WEST SUSSEX COUNTY COUNCIL CONSULTATION

TO:	Arun District Council FAO: Mr. S. Davis
FROM:	WSCC - Highways Authority
DATE:	30 th November 2021
LOCATION:	Land adjacent to Woodgate Nurseries Lidsey Road Aldingbourne PO20 3SU
SUBJECT:	AL/129/21/OUT Outline planning application with all matters reserved (except access) for residential development with up to 95 No dwellings (Use Class C3), informal and formal public open space, landscaping, drainage and other associated works. This application is a Departure from the Development Plan.
DATE OF SITE VISIT:	18 th November 2021
RECOMMENDATION:	More Information Required
S106 CONTRIBUTION TOTAL:	TBA

This is the first WSCC County Highways (CHA) response to outline planning application with all matters reserved (except access) for residential development with up to 95 No dwellings (Use Class C3), informal and formal public open space, landscaping, drainage and other associated works.

Figure 4.2 – Proposed site access junction

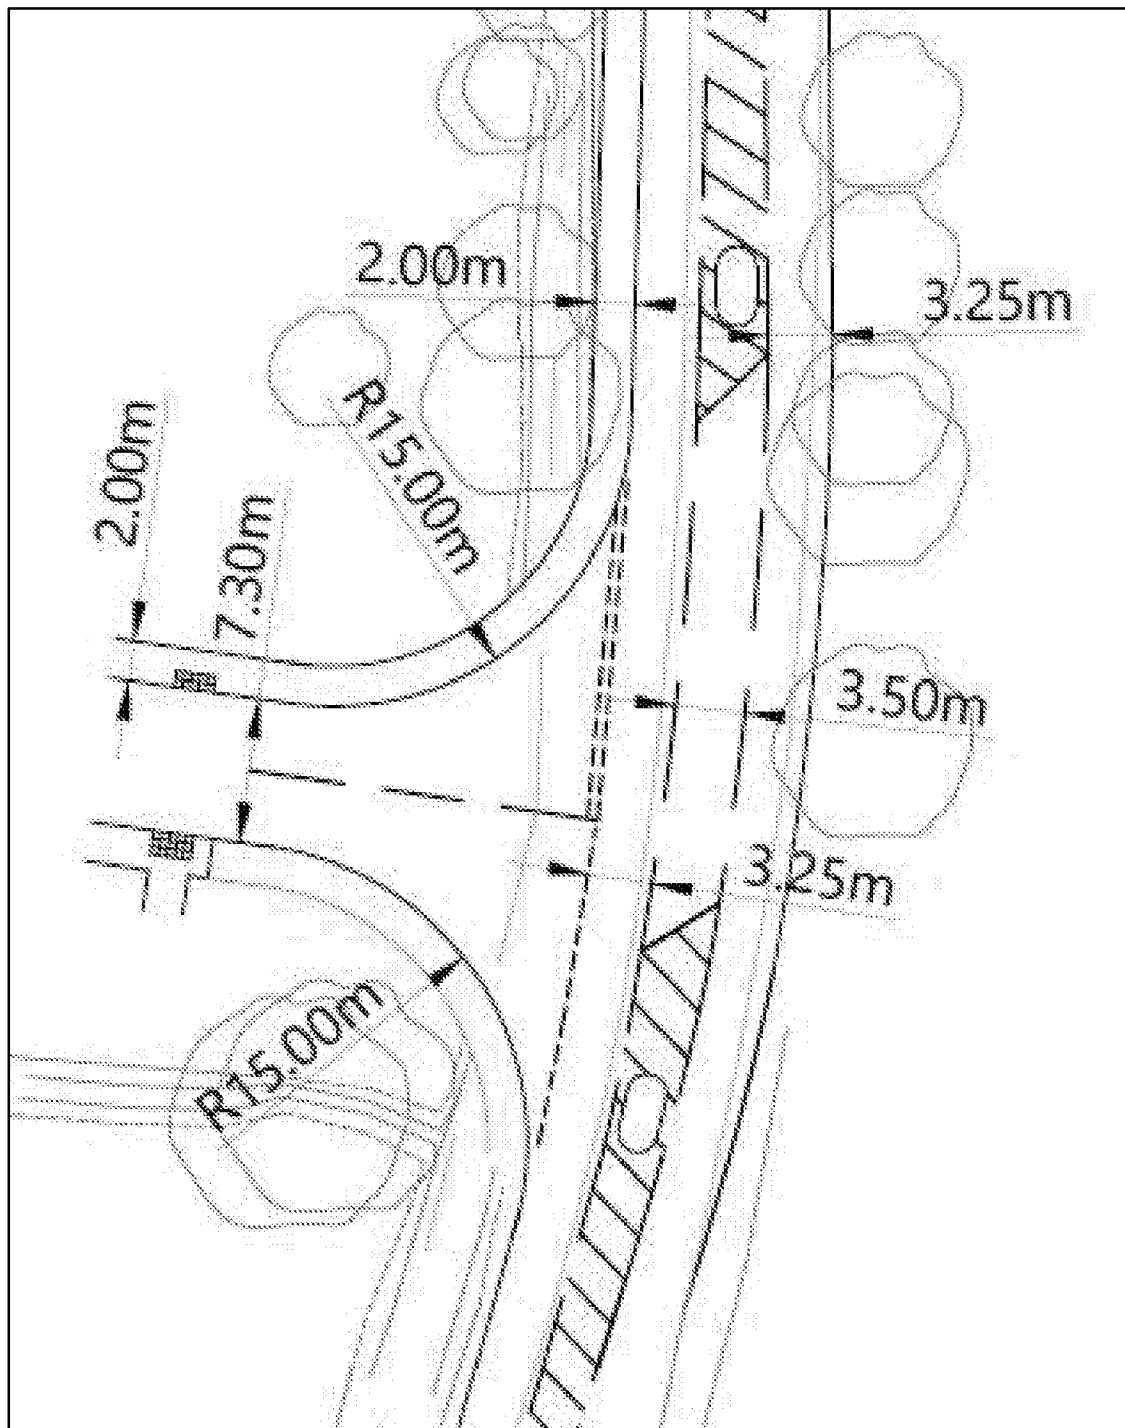
The site is located on the western side of the A29 Lidsey Road, Woodgate, with access shown taken off the same. This access is said to be shown on drawing HTp/2087/29/D found within the TA. However, this does not appear to be on the Arun DC website. Applicant to provide, please. The A29 connects Bognor Regis to the south with Fontwell to the north where it joins the A27.

The proposed access comprises a single point of access with right hand turning (ghost) lane on the A29 to assist with turning and traffic flow. This has been the subject of independent Road Safety Audit (to Stage 1). However, no formal design check against the requirements of DMRB has been provided by the applicant. This is required (as is the plan itself) in order for the CHA to be able to consider the design further. Any check should also state any departures and/or relaxations from standard identified and explain why any have been proposed. Sight line splays should also be shown based on the speed limit of the A29 at this location.

With regard to the accesses for the properties found on the eastern side of the road and in close proximity to the proposed site access, the applicant should show these on a revised plan and demonstrate that traffic movements to and from them would not be compromised with the provision of the site access and associated right hand turning lane proposed for the application site.

1. Recommendation - Remove vegetation to the north and especially south of the proposed access road. Investigate extending the existing 30mph further south to include the new junction.

2. Recommendation - Install junction warning sign prior to access road. Investigate extending the existing 30mph further south to include the new junction.

3. Recommendation - Reallocate road space or widen traffic island to ensure widths between 3.2m or 3.5m are avoided.

Overseeing Organisation Response (CHA) – This matter will be responded to again when a formal design check of all the component parts of the access works have been provided to the CHA by the applicant.

4. Recommendation - Construct the new footway such that its gradient is appropriate for pedestrian use. Ensure there is no level difference between the back of the footway and the adjacent verge and that pedestrians are protected from falling into the culvert using restraint.

Overseeing Organisation Response (CHA) – Agree with audit recommendation. That the footway be constructed with gradients appropriate for pedestrian use and ensure that there is no level difference between the back of the footway and the adjacent verge and that pedestrians are protected from falling into the culvert using restraint. However, if there is a difference in levels that a suitable restraint system be provided.

Design Organisation Response - Partially accepted. Vegetation within the visibility splays has been removed and will be maintained to ensure that the visibility splays will not be impacted. A note has been added to the updated access drawing (2087/29/D). There are no proposals to extend the 30mph speed restriction.

Agreed Action – That the access be constructed in accordance with the existing speed limit at that point on Lidsey Road and, furthermore, in accordance with other necessary design criteria as required in DMRB or as otherwise agreed with the CHA.*

Design Organisation Response - Not accepted. The access junction will be visible for around 300 metres for northbound vehicles which is considered more than sufficient. Nevertheless, a comment has been added to the access drawing stating: "Provision of permanent or temporary junction warning signage to be discussed with council engineers as part of the Section 278 process." Again, there are no proposals to extend the 30mph speed restriction.

Agreed Action – That signage be provided as-per the safety audit recommendation (actual type and whether temporary or permanent to be determined at S278 stage). And, that the access be constructed in accordance with the existing speed limit at that point on Lidsey Road and, furthermore, in accordance with other necessary design criteria as required in DMRB or as otherwise agreed with the CHA.*

Design Organisation Response - Not accepted. The access has been designed in accordance with DMRB GG 123 and verified by swept path analysis given the location of the access on a bend in the A29. GG 123 states:

Design Organisation Response – Accepted. The level difference between the edge of the existing road (bottom of kerb) and the edge of the site is approximately 0.35 metres. The footway into the site will be designed at maximum gradient of 1:20. Should there be any risk of pedestrians slipping or falling into the culvert, then providing a restraint system will be investigated. The site access proposals have been updated to reflect the above.

Agreed Action - That the footway be constructed with gradients appropriate for pedestrian use and ensure that there is no level difference between the back of the footway and the adjacent verge and that pedestrians are protected from

falling into the culvert using restraint and if there is a difference in levels, that a suitable restraint system be provided.
